October 29, 2025
Development Facilitative Team (DFT)
600 2nd St NW, Albuquerque, NM 87102

RE: Project: PR-2022-007565; SP2025-00075- SITE PLAN DFT Comment responses

To whom it may concern,
I am in receipt of comments provided on 10/22/2025 and have provided the following revisions, and responses to those comments:

AS102

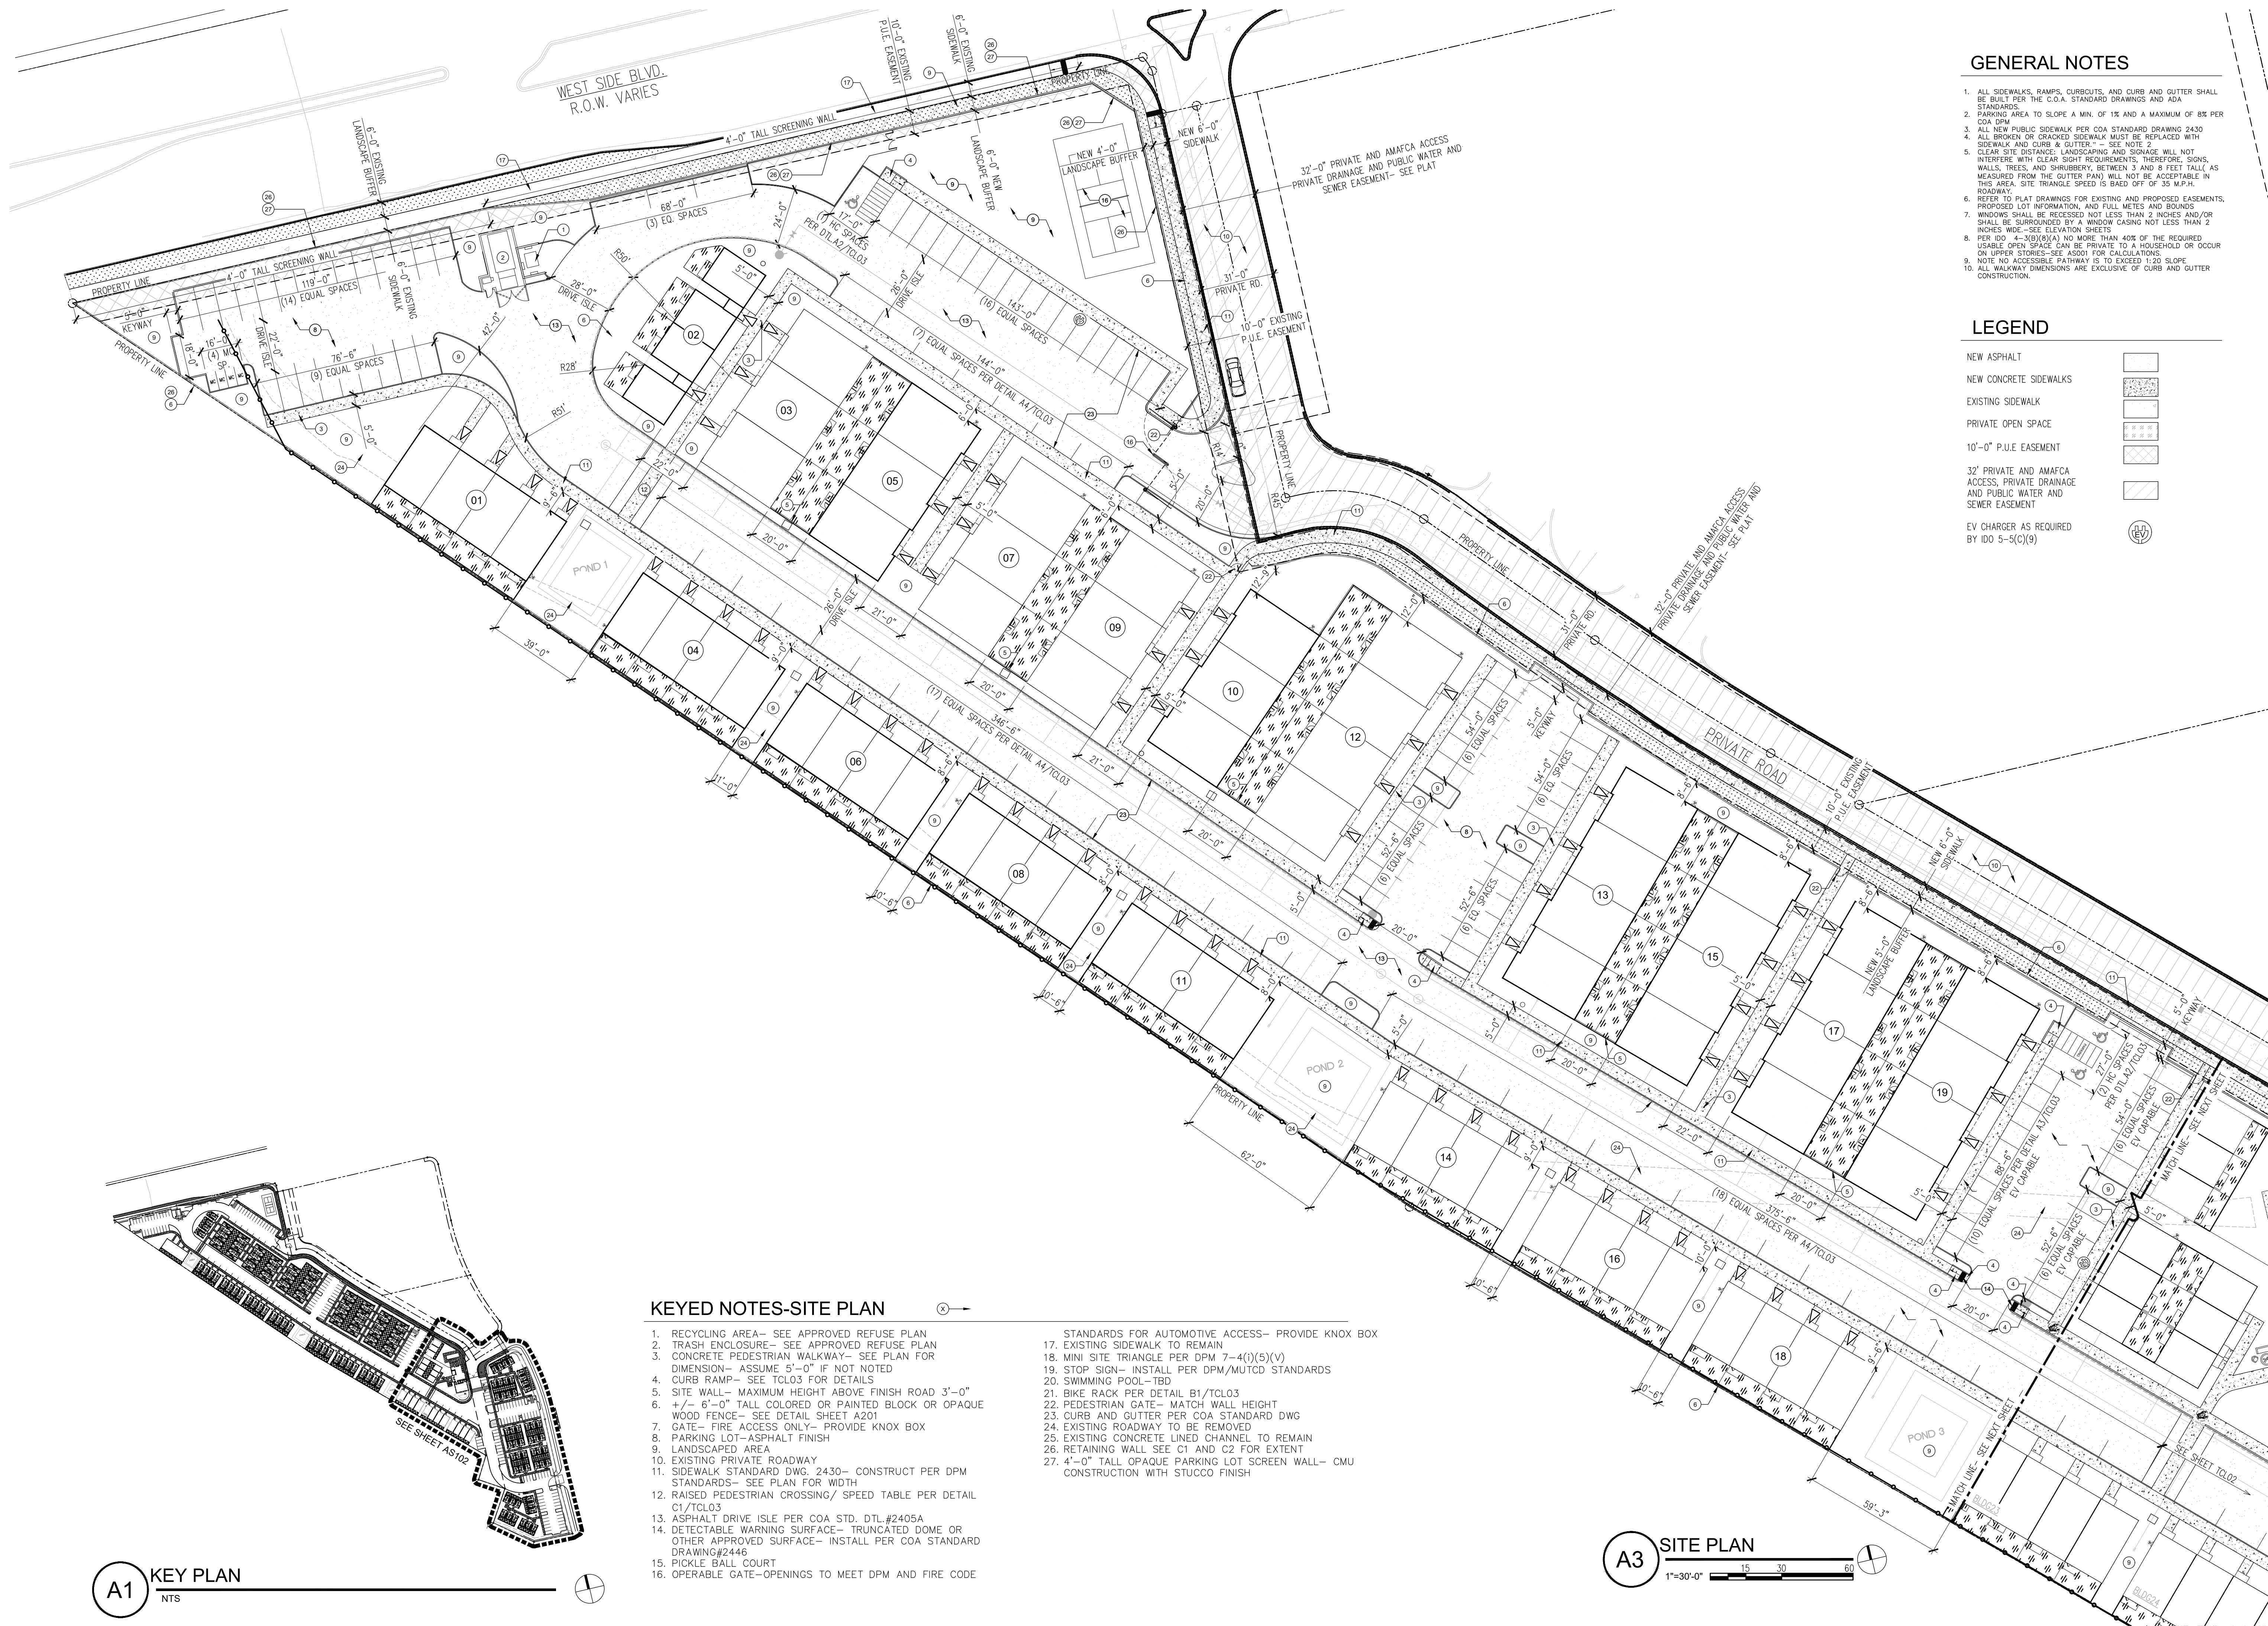
1. Wall along Westside is shown as a 6-foot opaque wall. However, the wall height is limited to 3 ft in height in front yard setback, as per IDO 5-7(D) Table 5-7-1, or up to 4 feet on the front parking lot edge as meeting a parking lot buffer requirement, as per IDO 5-6(F)(1)(i).

2. Parking spaces along Westside require parking lot buffer wall, as noted above, or will require a 10-foot landscape buffer, as per the same section, IDO 5-6(F)(1)(i). This is cited in the Landscape Plan note #9, but it does not appear to be implemented

2. Are any walls are being proposed along Westside Blvd.?

Response: Site plan has been revised to show a 4'-0" screen wall along the front parking lot edge. This wall will provide the required parking lot buffer as indicated in Comment #2.

Response: A 4-foot tall parking lot screen wall will be used for in lieu of the 10-foot landscape buffer referenced.
3. Lighting: Light fixtures, IDO 5-8(E): General Design and Illumination Standards. Provide documentation showing how requirements are being met:

Response: There will be a 4-foot parking lot buffer wall installed along Westside Blvd. See Responses #1 and #2 for Code Enforcement.

LP-02

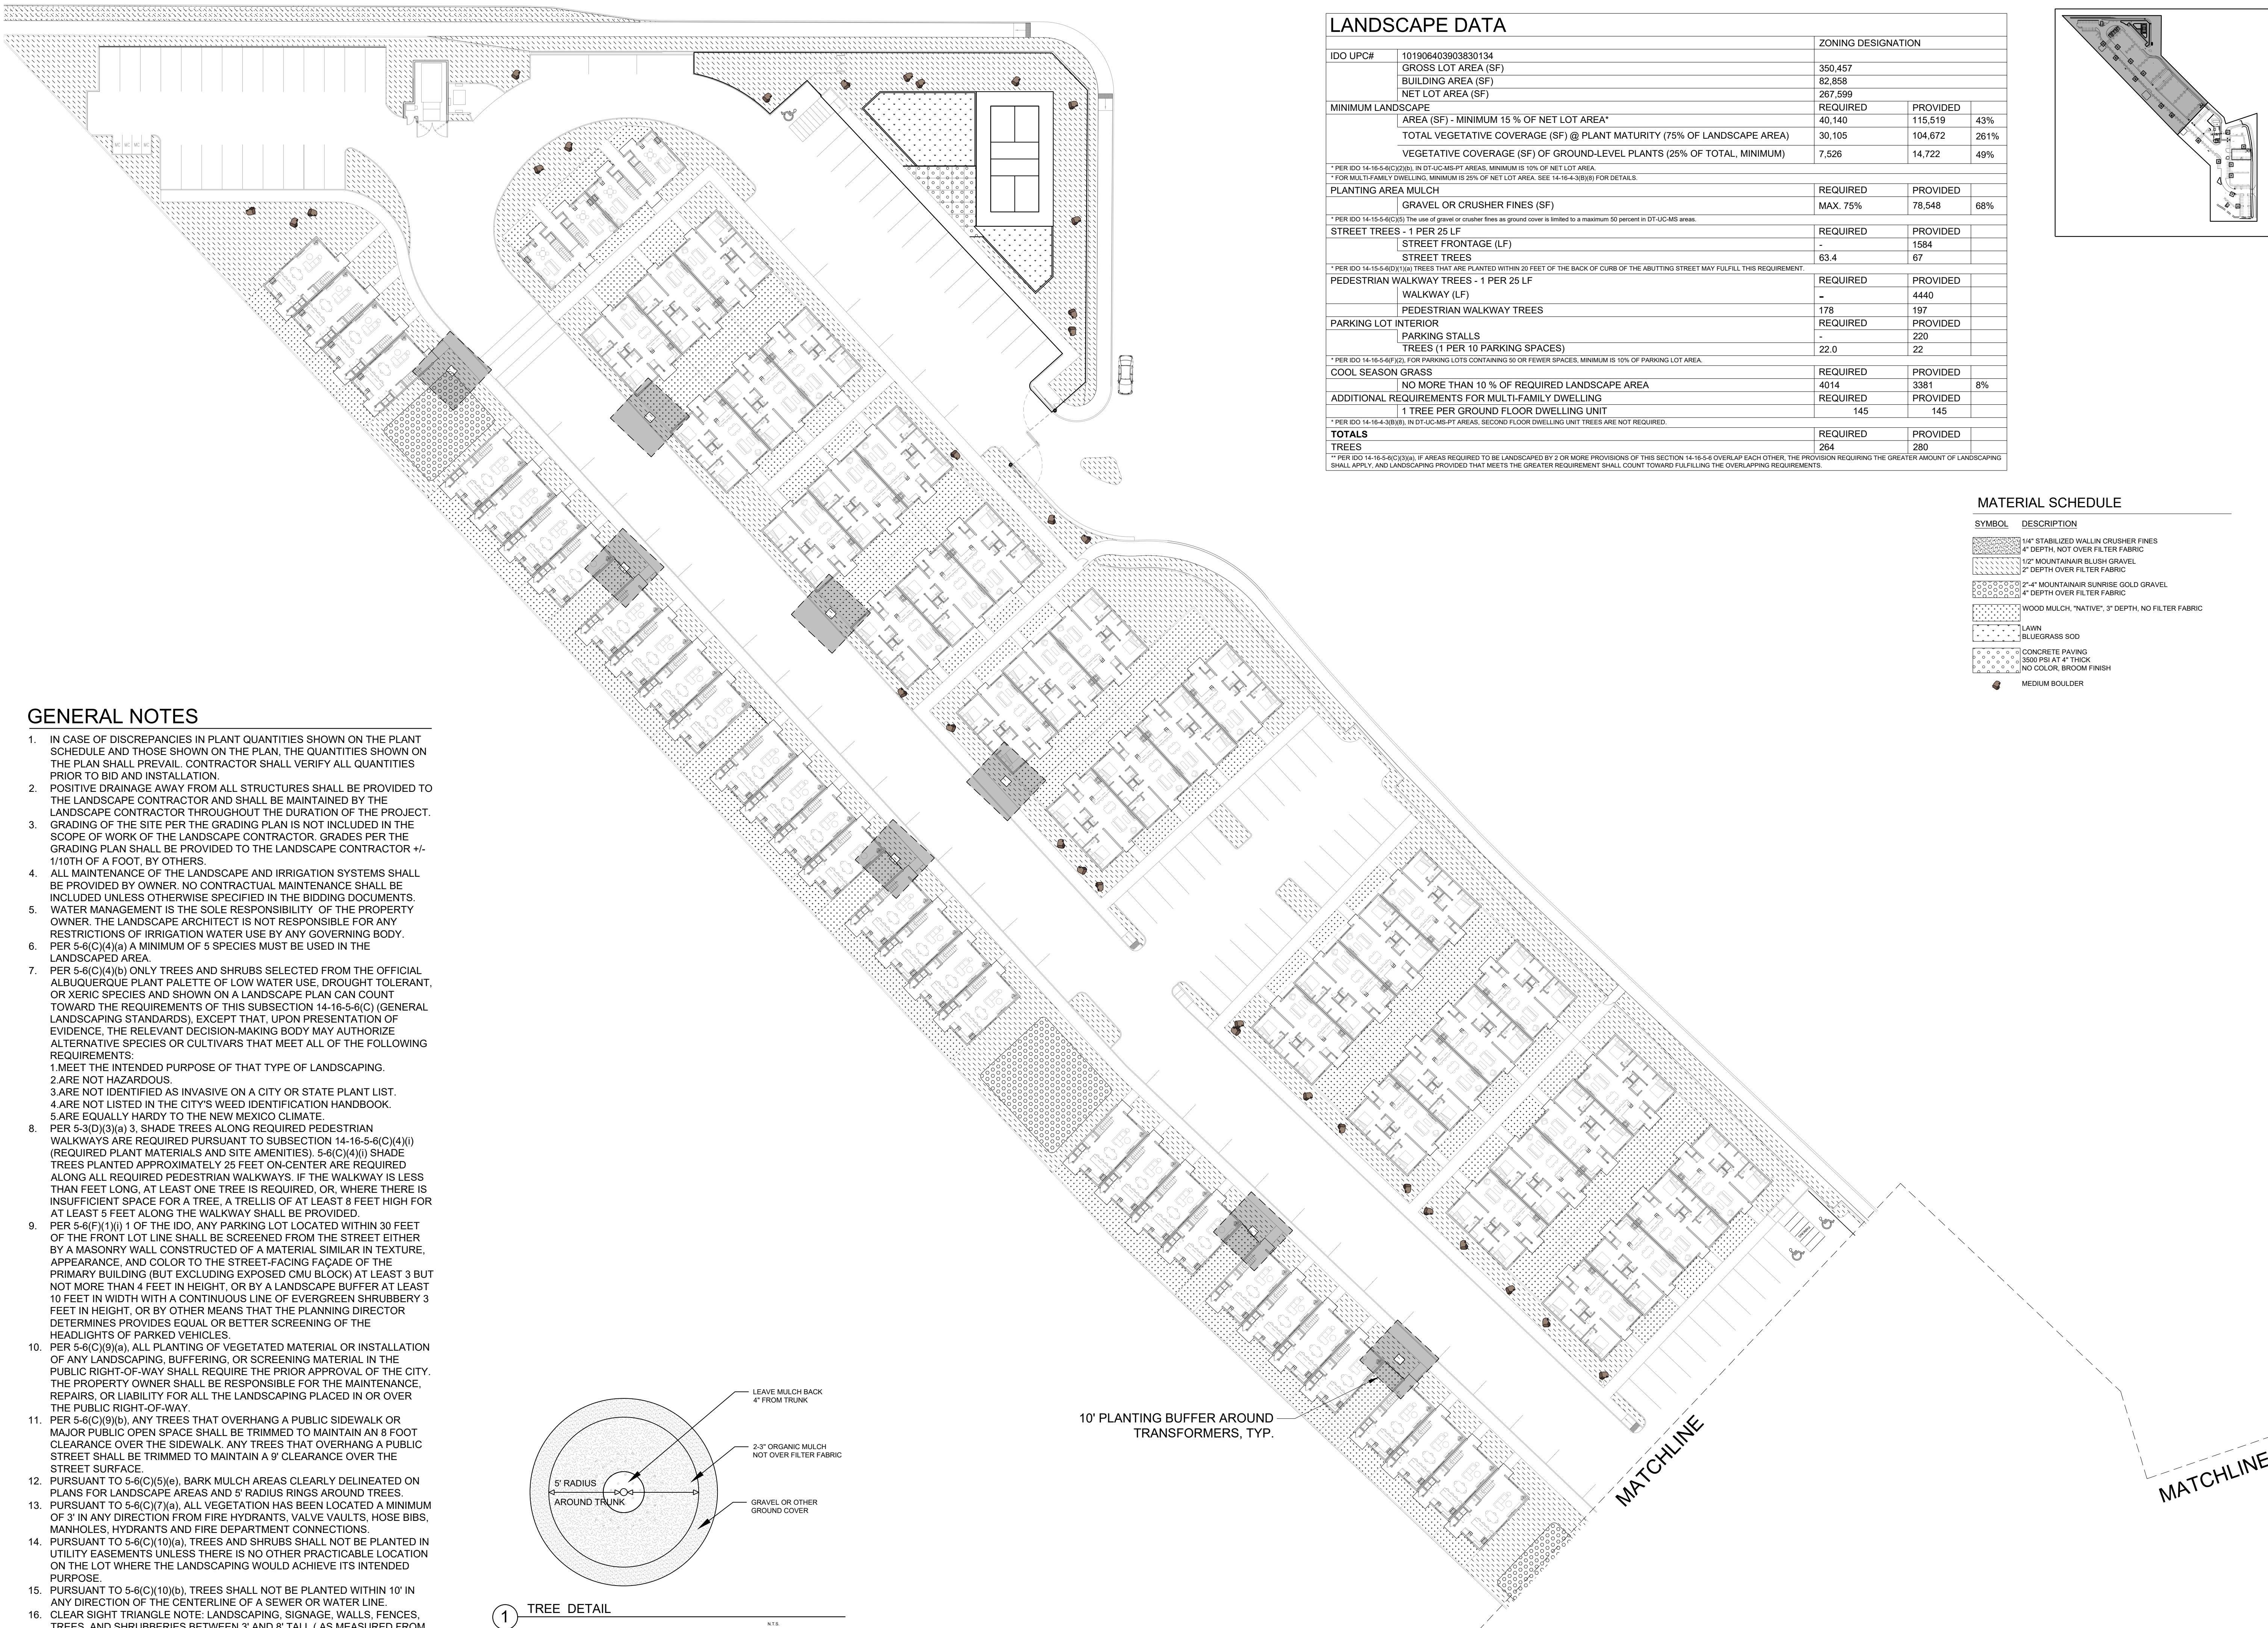
2. One (1) tree is required per 10 parking spaces. Calculations must be added to the landscape plan data.

5. Add the gravel coverage calculations for the 1/2" Blush Gravel and 2-4" Gold Gravel.

4. Serviceberries struggle with heat and high UV rays and are only recommended as an understory planting, per local nurseries. Serviceberry is also not on the Official Plant Palette. Please replace it with another species.

Response: This has been added to drawings

Response: This has been added to the drawings

Response: Serviceberry has been removed from the project and replaced with plants from the official plant palette.
